## **Application by Highways England for an Order Granting Development Consent for A57 Link Roads**

### **Deadline 5 - response on behalf of High Peak Borough Council**

Responses from High Peak Borough Council are provided in blue to outstanding matters discussed in the hearing session held during the week commencing 7<sup>th</sup> February 2022 in relation to noise and vibration.

**6.4 Environmental Statement
Figure 11.3 - Construction Noise and Vibration
Study Area**

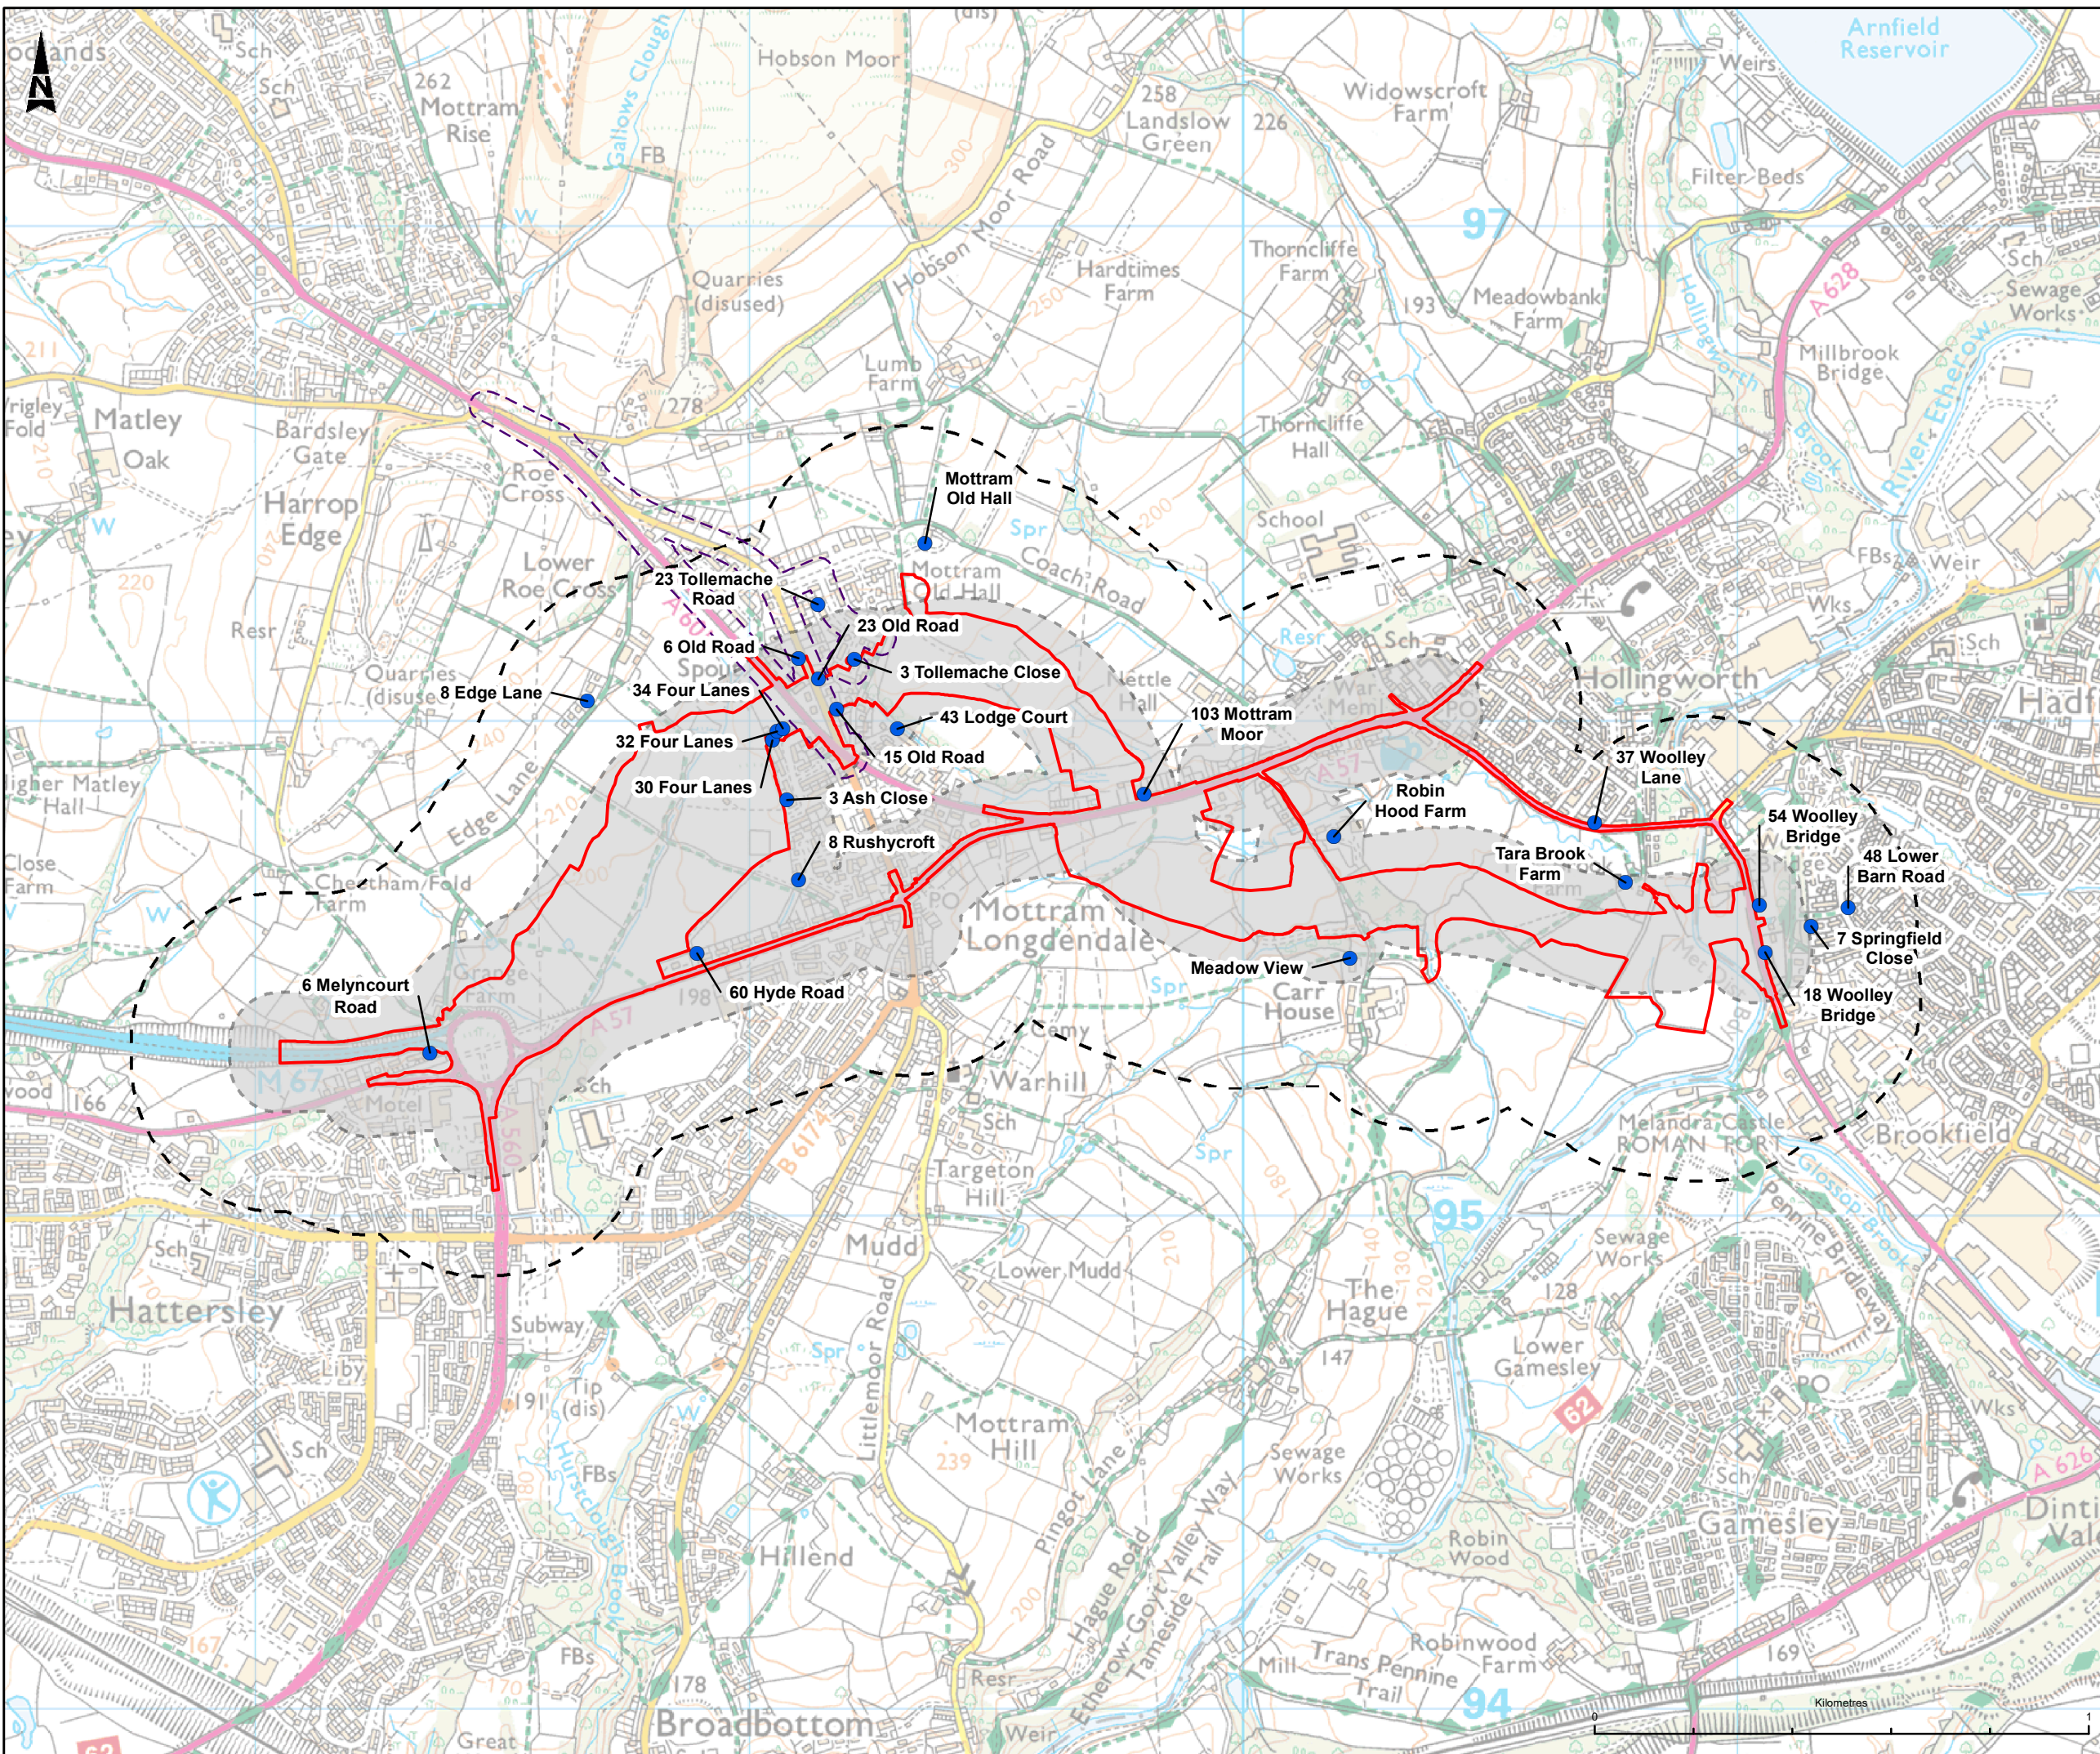
The issue therefore, is an understanding the potential noise impacts from these various activities, when undertaken in accordance with BPM (e.g assumed embedded mitigation) and crucially the anticipated frequency of these works ( para 1.34 i - ix ), to understand if it should be accounted for in the ES

Typically, if an activity is infrequent or unexpected then section 61 then, it would not be anticipated in would be included in the assessment. However, if some of the activities listed are likely to become embedded, for example, nightly routine equipment maintenance then this should be included. There is also possibly some unknown element to this, as the application of the Section 61 is appears to be at the discretion of the Principal Contractor.
